Mark E. Jones, PE
Structural Engineering and Design

Ref: Site Observations and Analysis
4131 Mcdougald Rd.
Lillington, NC
Project No. 21-144

**FOUNDATION PLAN**  
1/4" = 1'-0"

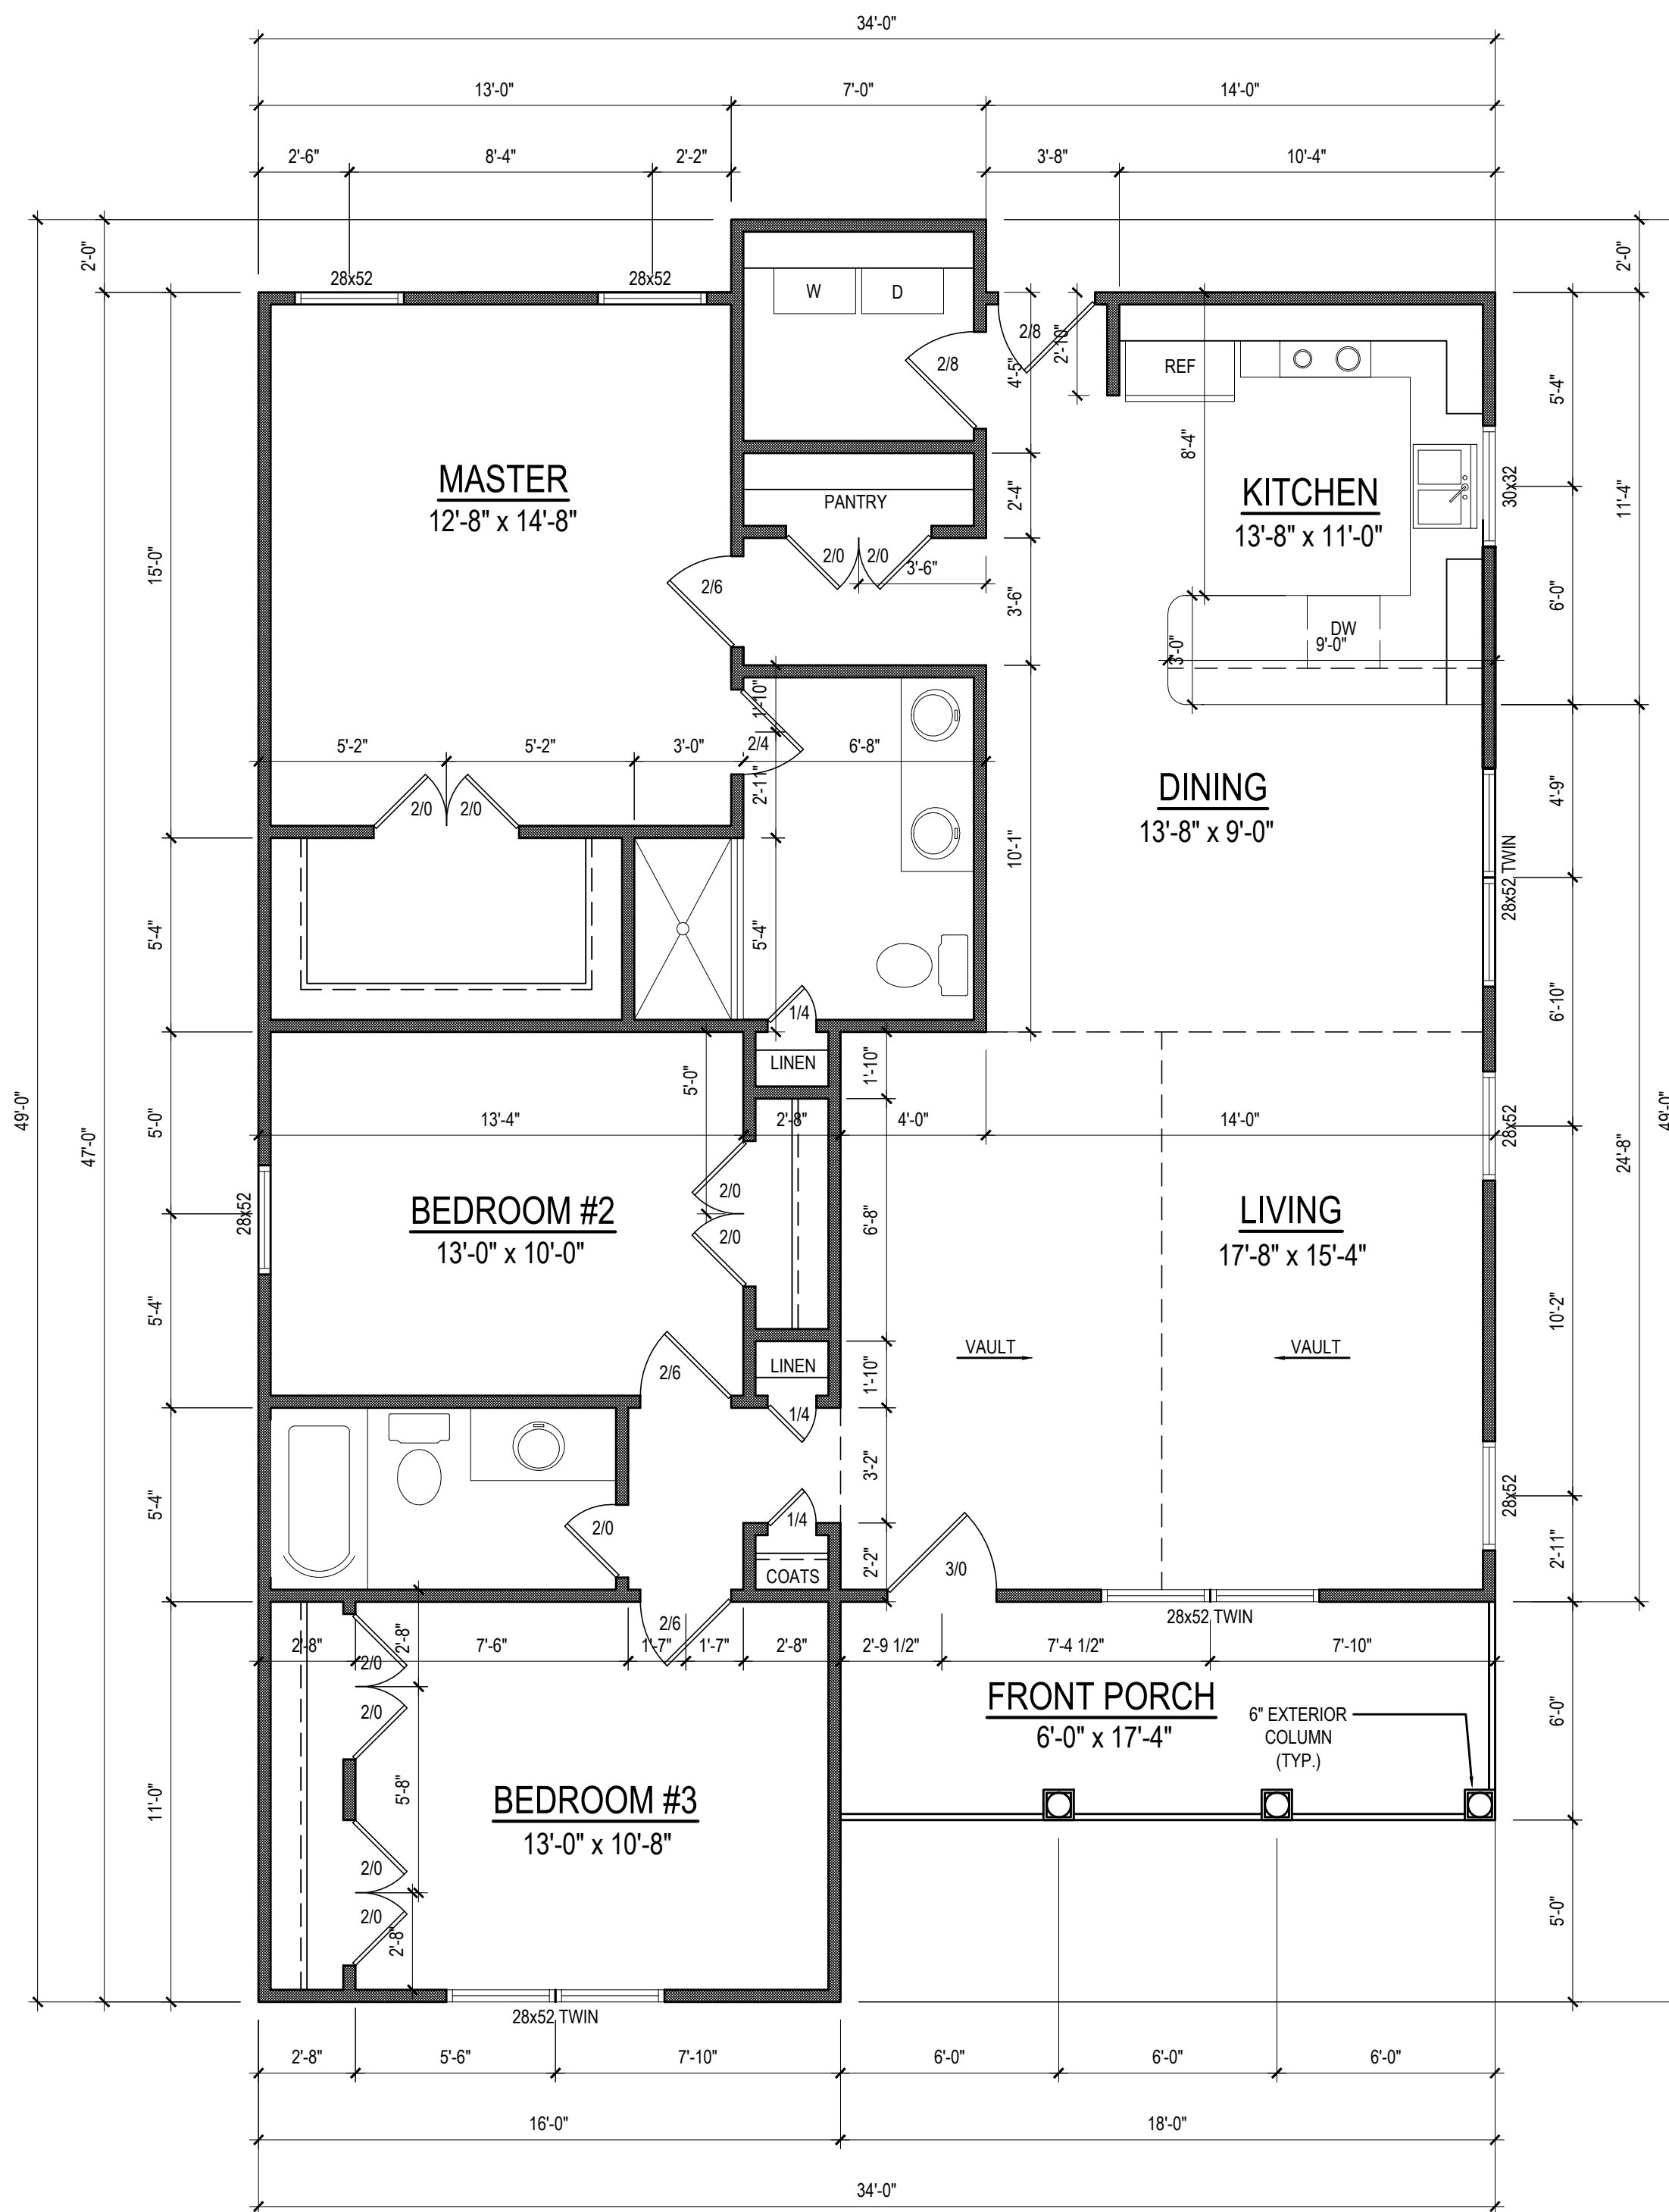
1. The first pier on each row appears not to be in the center 1/3 of the footing. Right side.

1. The footings for the referenced piers were over excavated to approximately 42"-46" wide. The center of the girder load resting on the pier will still be located in the center third of the pier. No repair is required.
